Re: Bull Mosse Plans (317 B005) **CC:**

Notes: I have commenced the review of the plans and need the following

prior to the issuance of either the foundation permit or the structure permit:

User Defined Frame Point Loads for Cross Section: 1

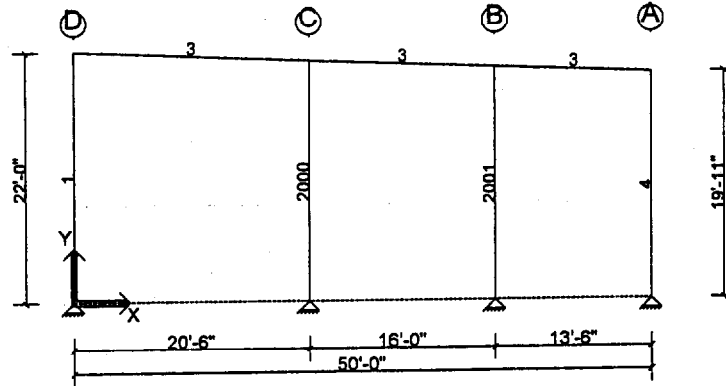
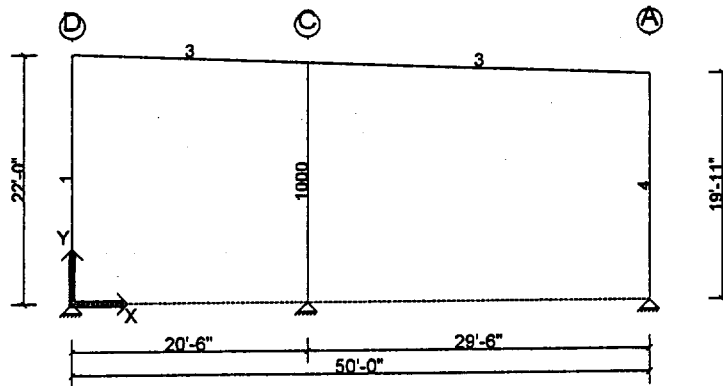
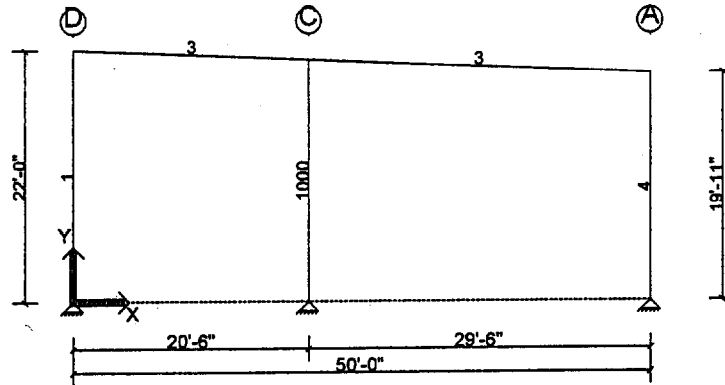
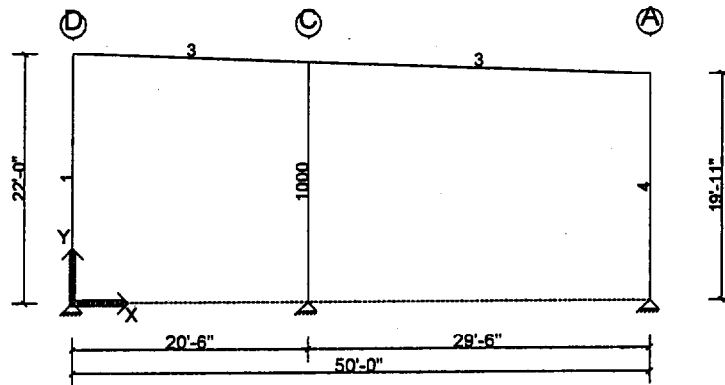
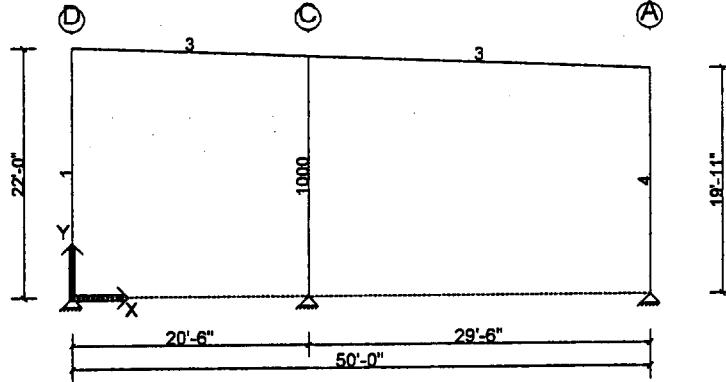
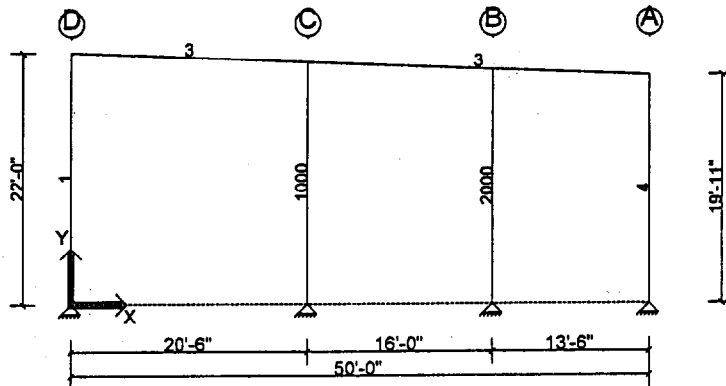
1) It appears that the Mezzanine is not accounted for in the original steel plans from VP buildings. Does this additional load affect the size, spacing or design of these components as well as their footings/foundation.

TYPICAL FROST WALL DETAIL

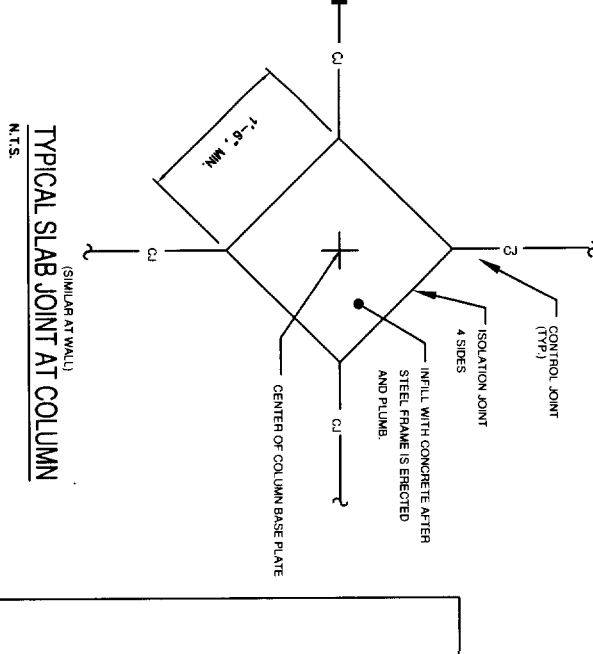
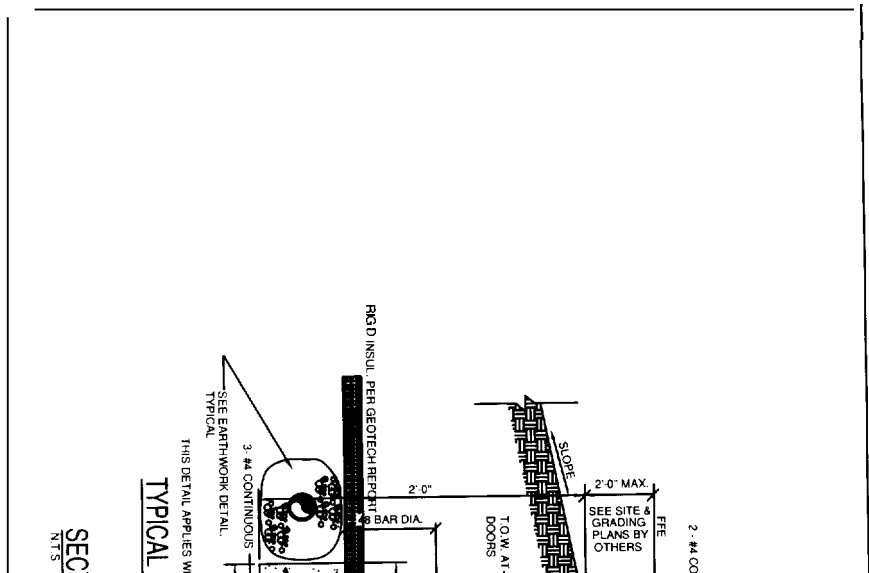
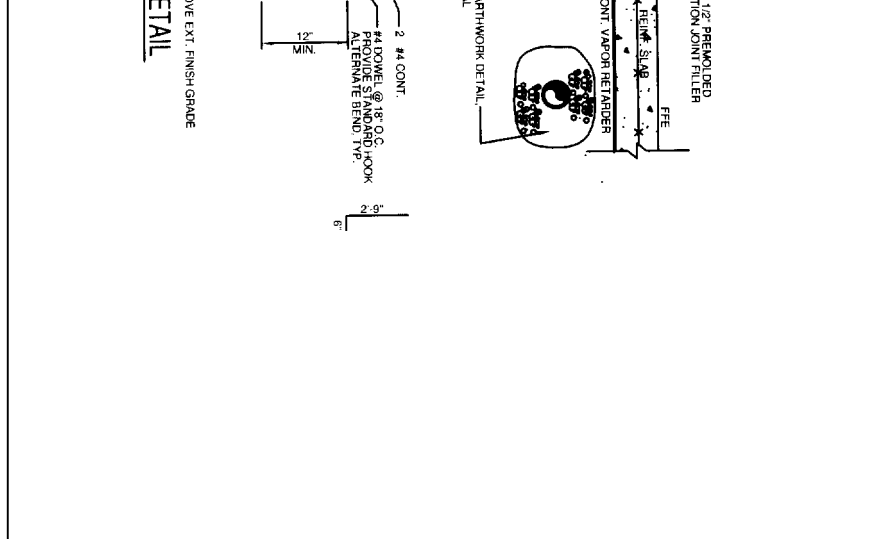
3) Is the 6 inch thickness of unreinforced concrete in details "d" and "a" of the foundation Code compliant? I find no foundation wall thicknesses of less that 7.5 inches in Section 1812 of BOCA
